DRB Application No.: 07DRB-00514 (P & F) Project # 1003128  
 Project Name: NORTH ALBUQUERQUE ACRES, UNIT A  
 Agent: JOSH SKARSGARD Phone No.: 998-9094

**CITY OF ALBUQUERQUE  
PLANNING DEPARTMENT  
April 25, 2007  
DRB Comments**

**RE: Lots 1-5, Block 11, N.A.A., Unit A/minor plat**

PLAT OF  
 LOT 5-A, BLOCK 11  
 (BEING PORTIONS OF LOTS 1-5, BLOCK 11)  
 NORTH ALBUQUERQUE ACRES  
 TRACT A UNIT A  
 WITHIN THE ELENA GALLEGOS GRANT  
 ALBUQUERQUE, BERNALILLO COUNTY, NEW MEXICO  
 APRIL, 2007

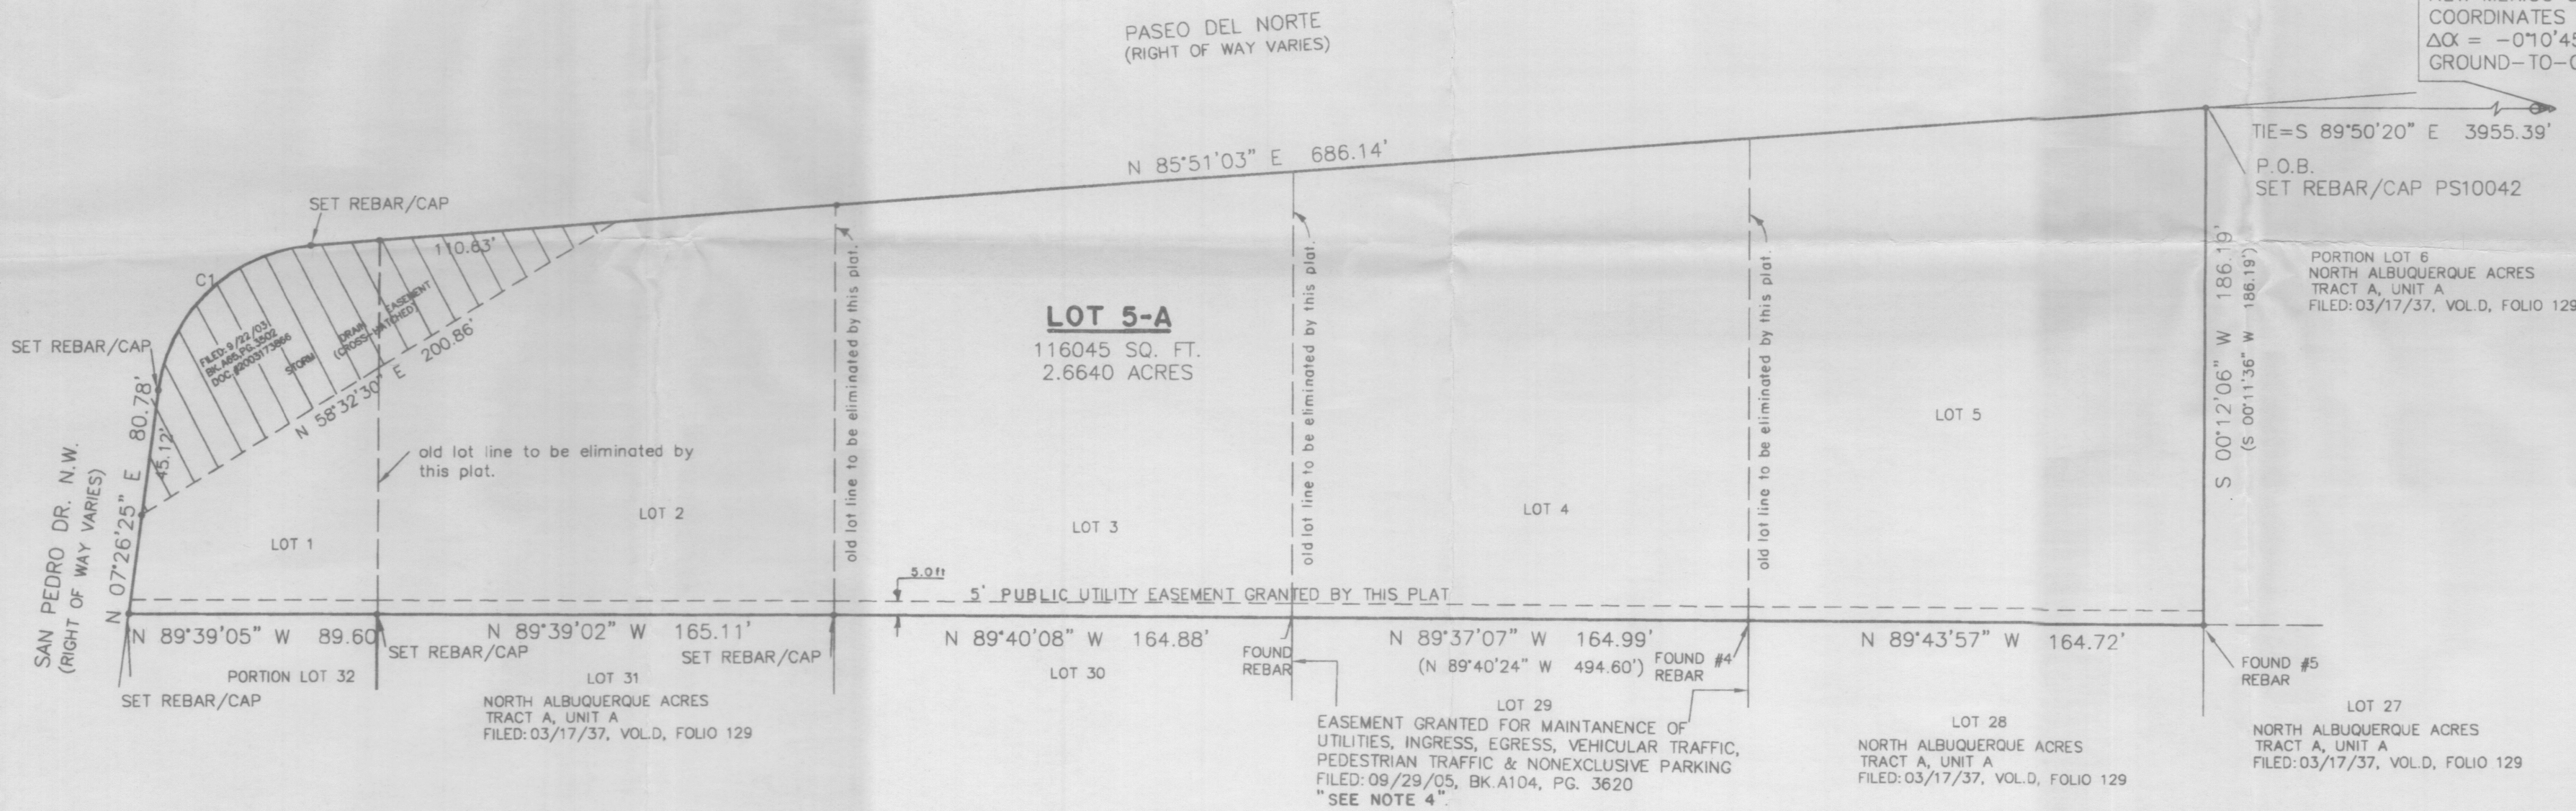
The zoning is missing on the plat.

There is no APS requirement as the zoning will change to SU2-C1 when the plat is filed per EPC condition of approval of the zone change request.
